Bramford to Twinstead Reinforcement

Document 8.9.4: Applicant's Comments on Other Submissions Received at Deadline 6

Final Issue A
January 2024

Planning Inspectorate Reference: EN020002

DEDHAM VALE EAST SEALING END COMPOUND:
 PLAN VIEW
 SCALE 1:200

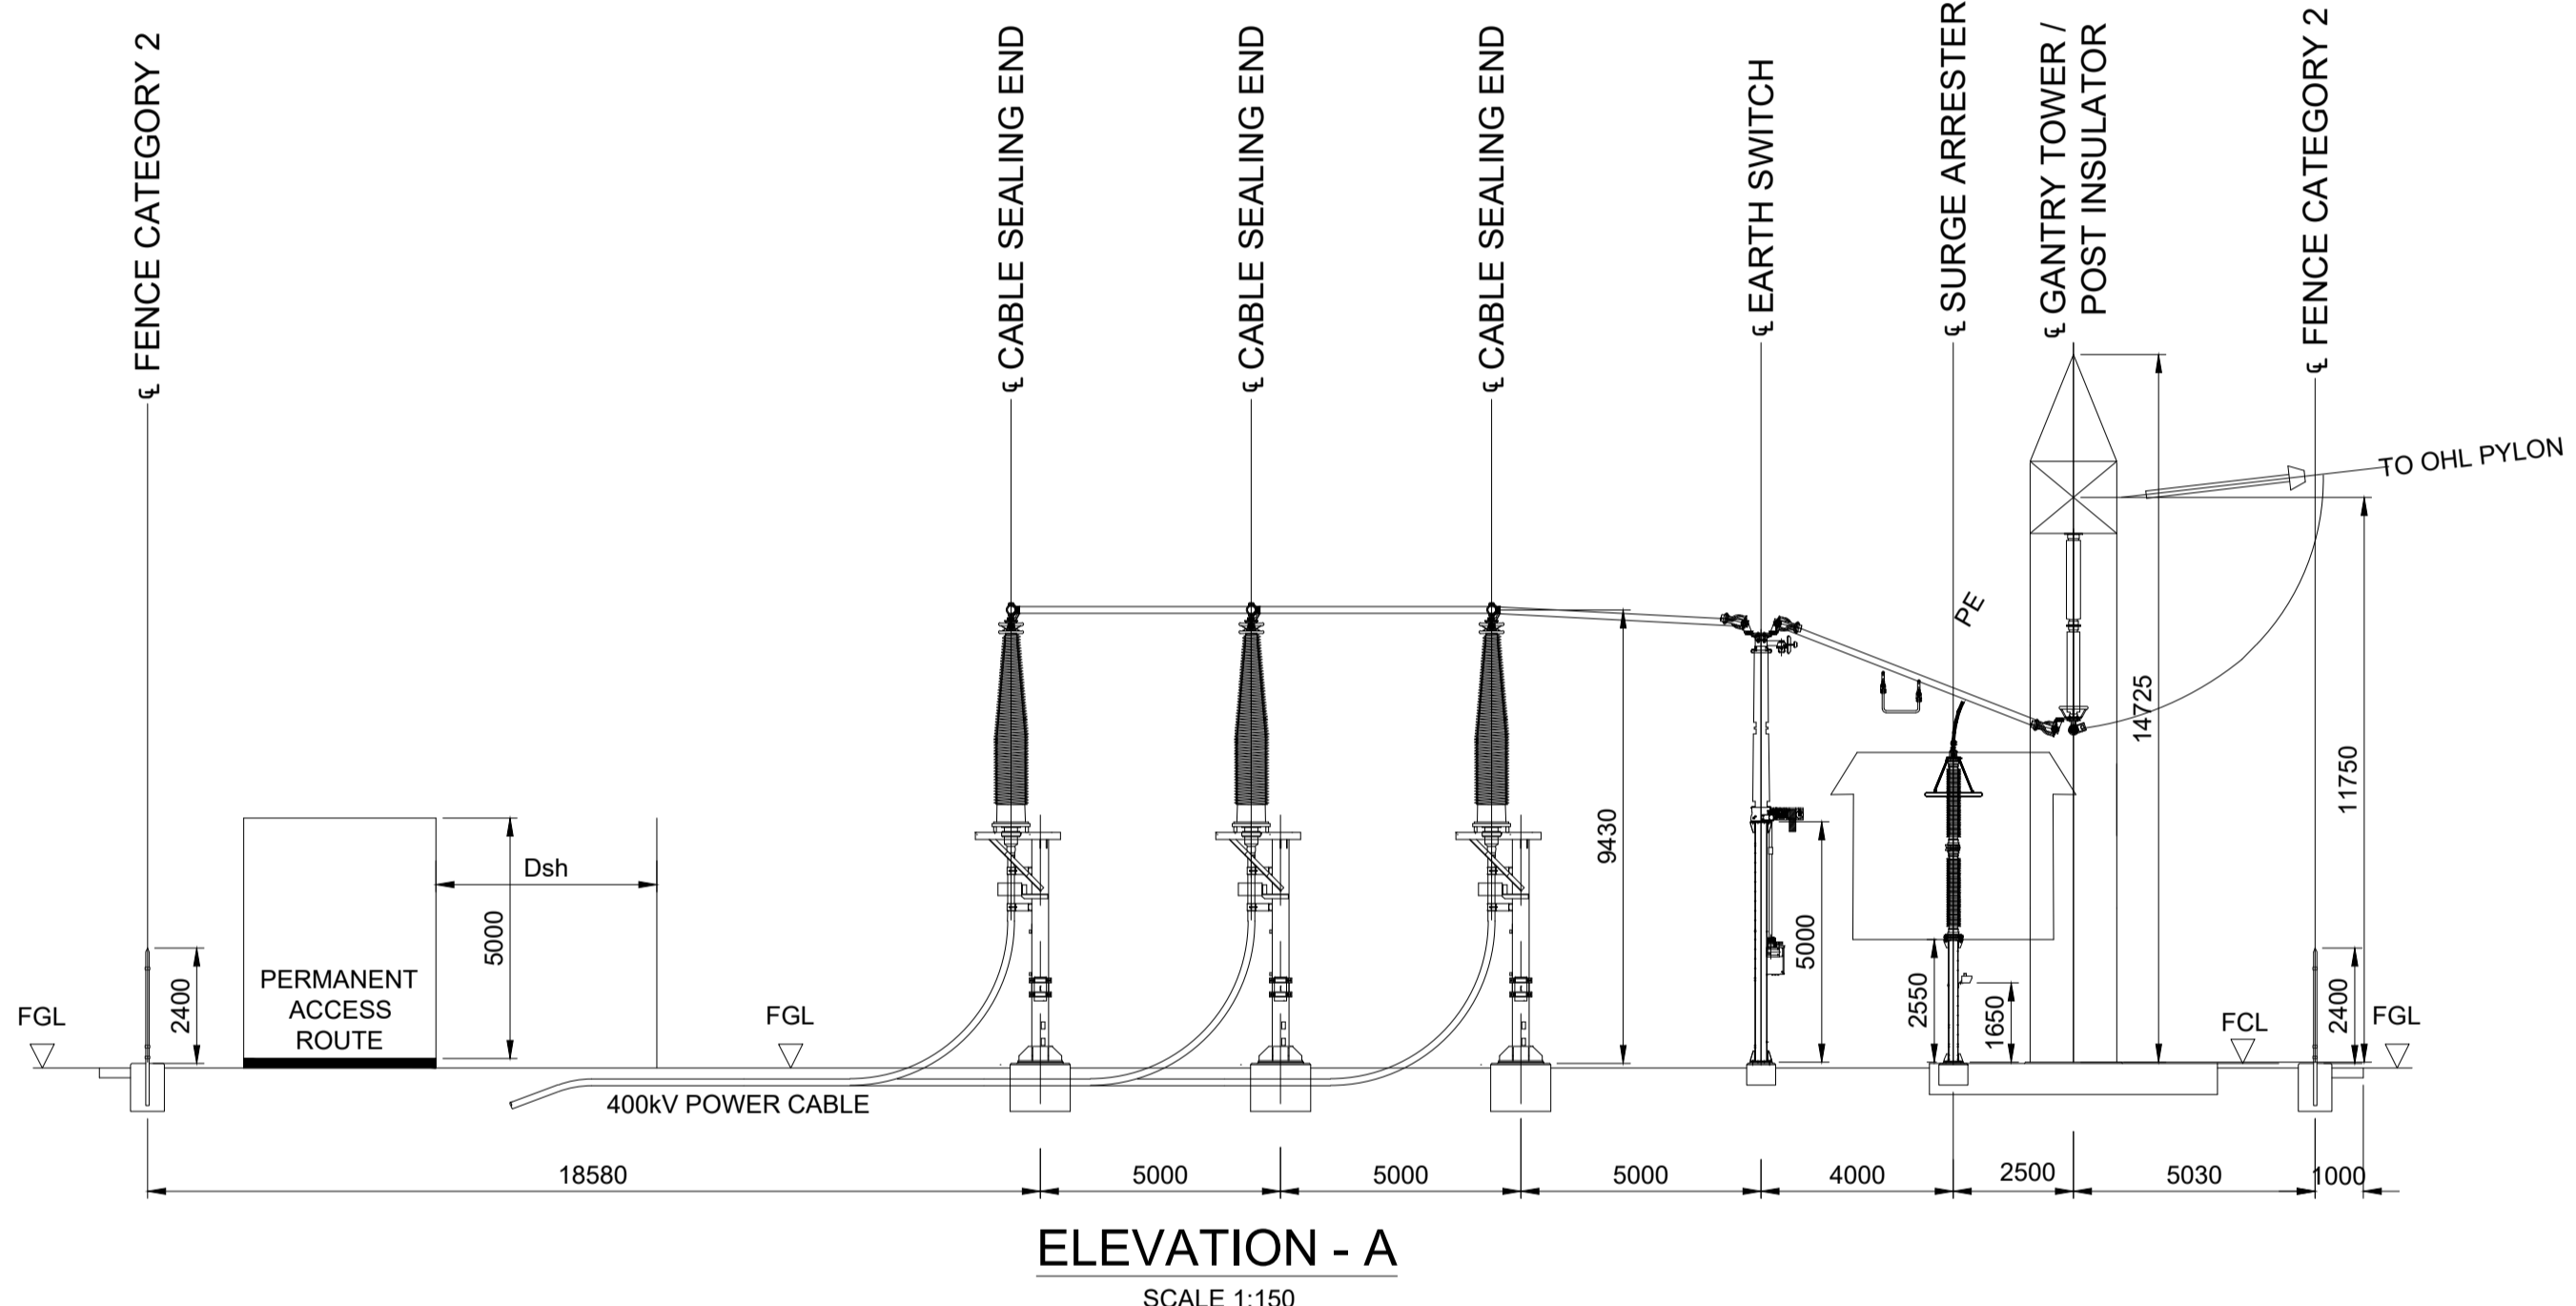
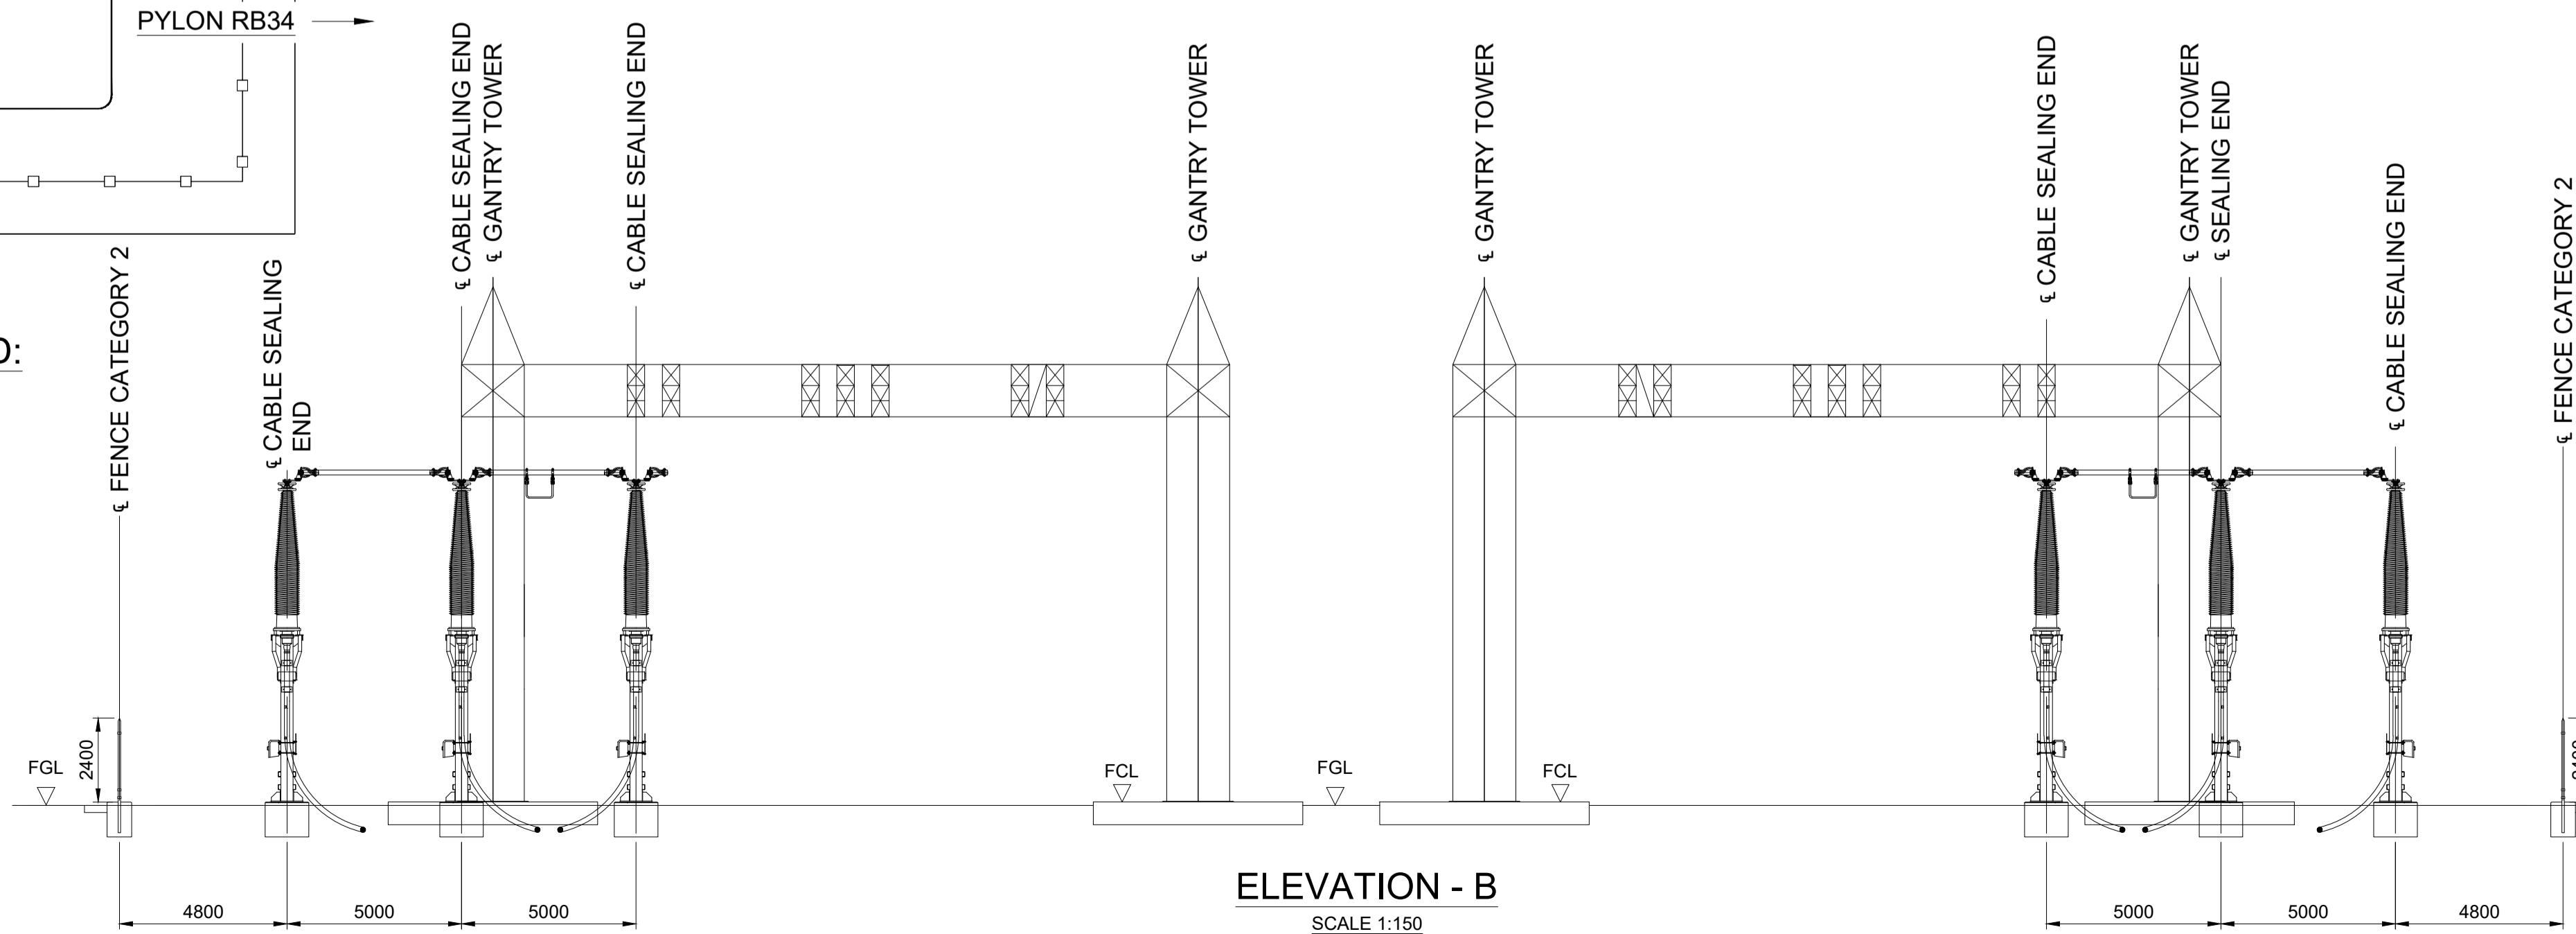
- 2.3.3 Babergh and Mid Suffolk District Councils notes that they still have concerns and comments in respect to the Dedham Vale East cable sealing end (CSE) compound and Stour Valley East CSE compound. The Applicant responded to specific points on these in the Applicant's Comments on Other Submissions Received at Deadline 5 [REP6-045] in Section 2.4 and Table 7.1 respectively.

The Applicant updated Requirement 9 of the draft DCO [REP6-003] at Deadline 6 to confirm that the reinstatement planting plan submitted to the relevant planning authority must include a landscape plan for each CSE compound, which will show the proposed hard and soft landscaping and proposed finishes for hard landscape features in response to the Councils on this matter.
